Application Ref:	3/2026/0170			 Ribble Valley Borough Council www.ribblevalley.gov.uk
Date Inspected:	N/A	Site Notice:	N/A	
Officer:	AR			
DELEGATED ITEM FILE REPORT:				APPROVAL

Development Description:	Variation of condition 2 (approved plans) of planning permission 3/2024/0606 to allow an increase in the height of the roof.
Site Address/Location:	16 Sutherland Close Wilpshire Blackburn BB1 9LT

Project Name	Project No.	Stage
Rose Hill Farm	219.25	Planning Submission
Proposed Outbuilding		
12		
Scale	1:100 @ A1	
Date	January 2026	
Rev D	Drawn	RP

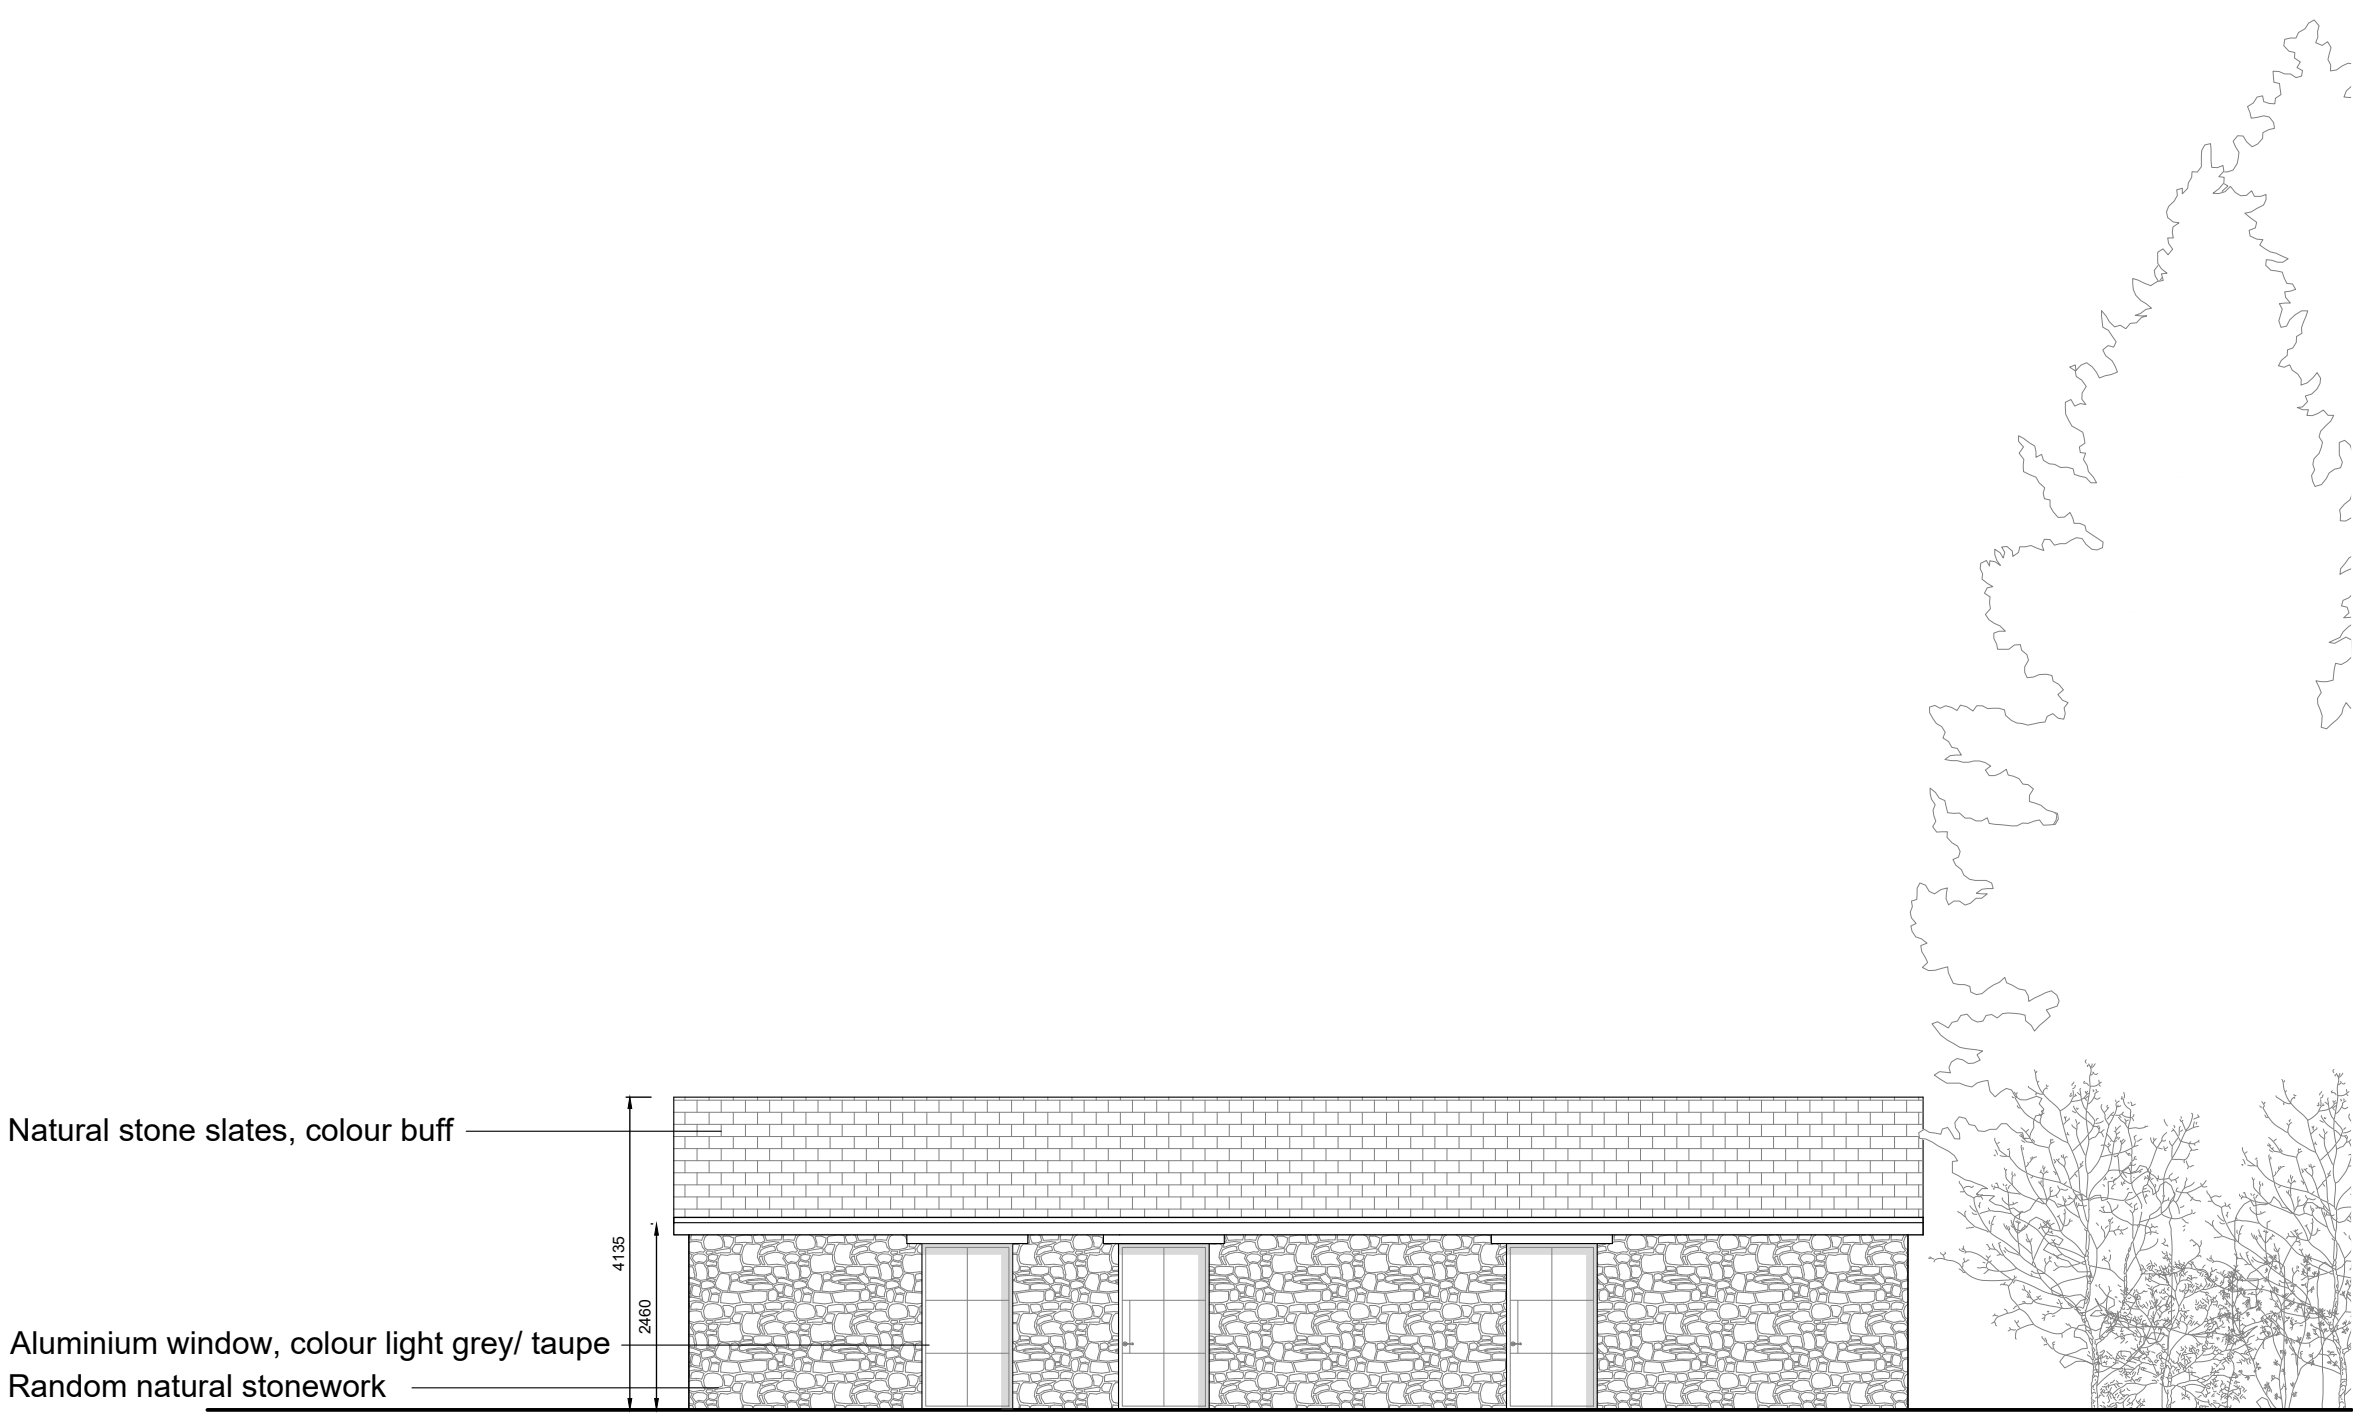
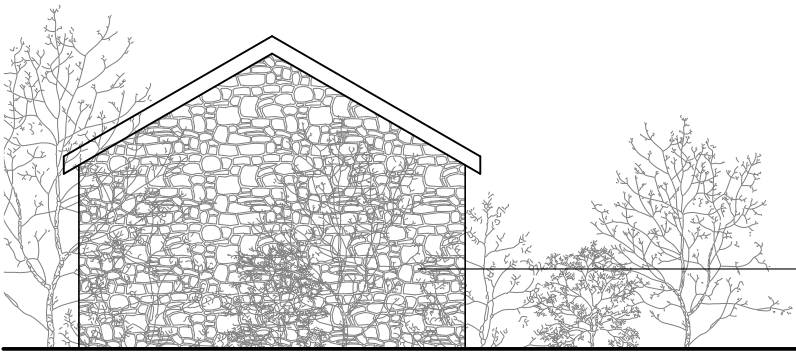
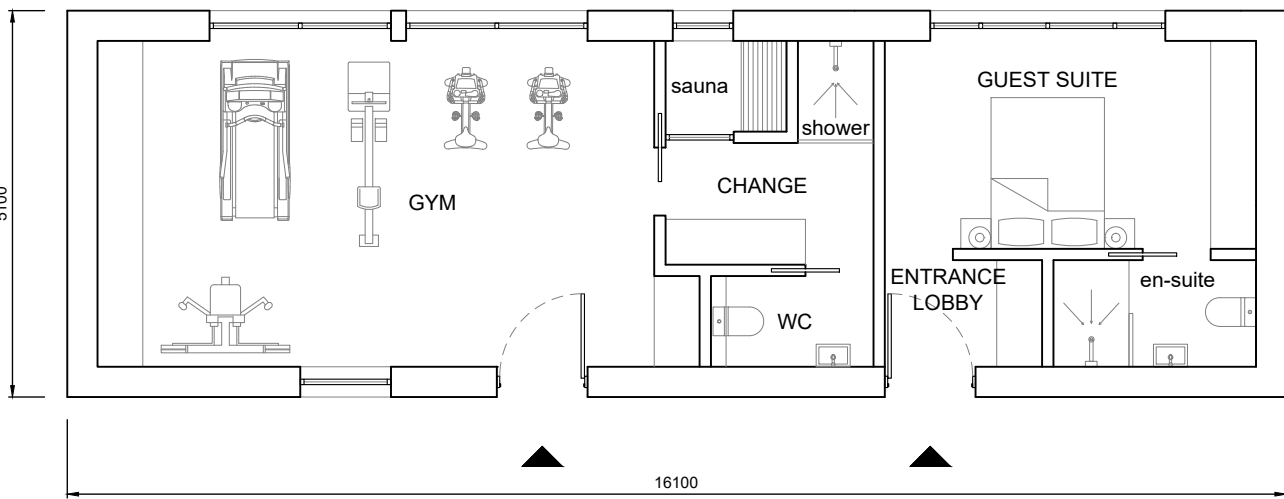
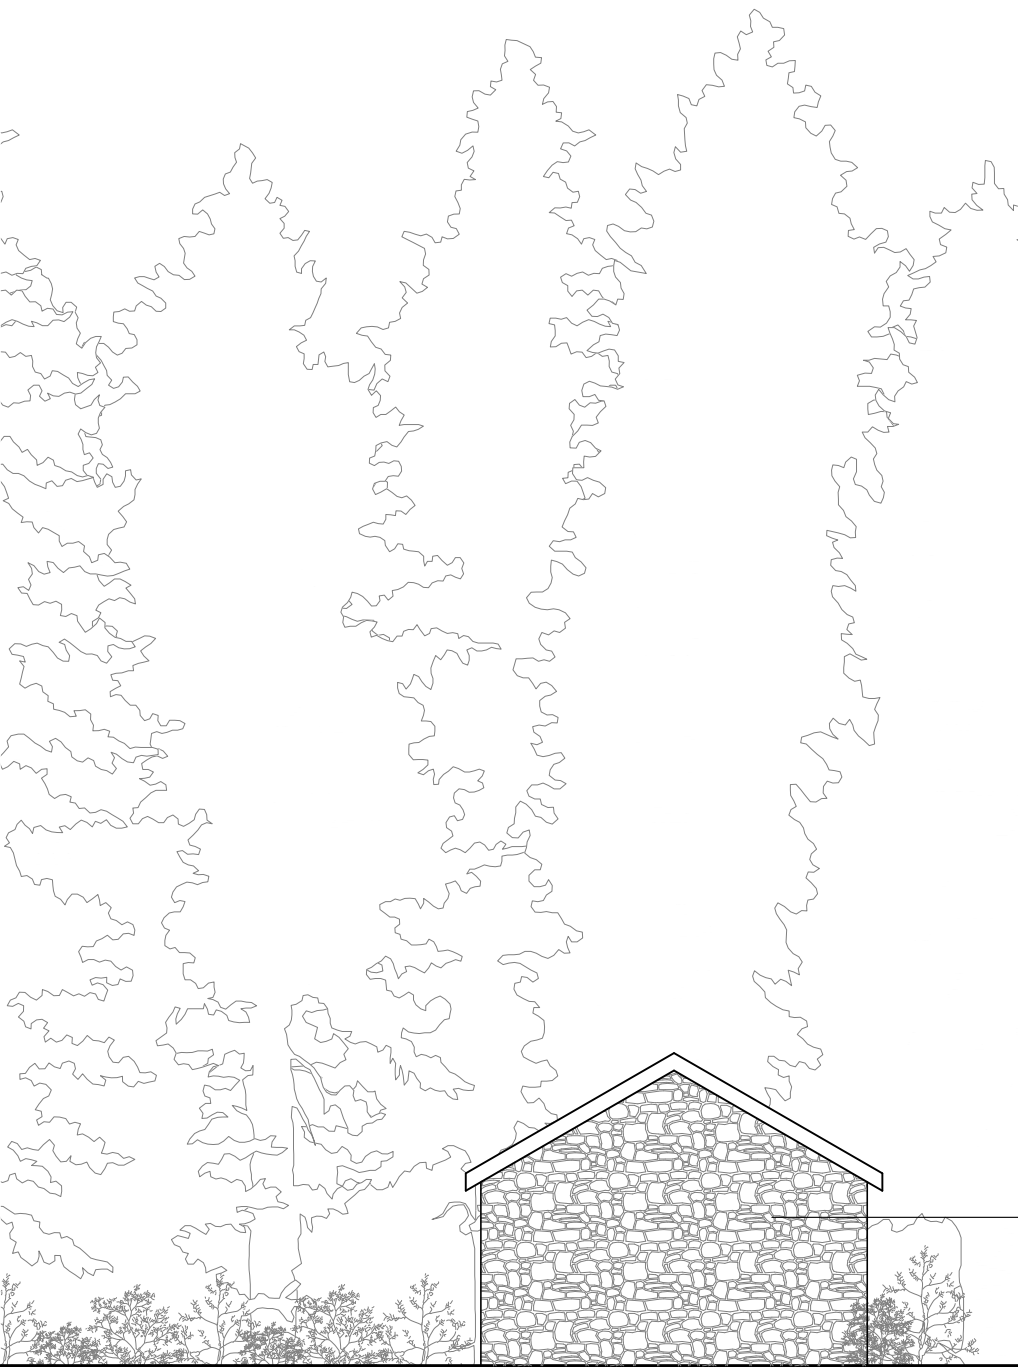
The roof ridge line of the garden room would stand at a maximum height of 3.2m, 0.2m higher than the previously approved maximum ridge height. The eaves height would stand at a maximum height of 3.025m, 0.5m higher than the previously approved eaves height. Desktop analysis showed that this increase in height to the eaves and roof pitch would not impact upon either of the adjacent neighbouring properties. Consequently, it is not considered that the proposed amendments sought to the originally approved development would be harmful to the amenity of any neighbouring residents.

The proposed detached garden room is located at the rear of the application dwelling; as a result, it is largely screened from the public realm. The roof ridgeline of the approved outbuilding would be viewable from PROW FP7, which runs past the bottom of the garden; however, desktop analysis showed that this increase in height would not disrupt the collective roofscape topography shared between the application property and the neighbouring dwellings. Accordingly, it is not considered that the amendments sought to the originally approved development would harm the area's visual amenities.
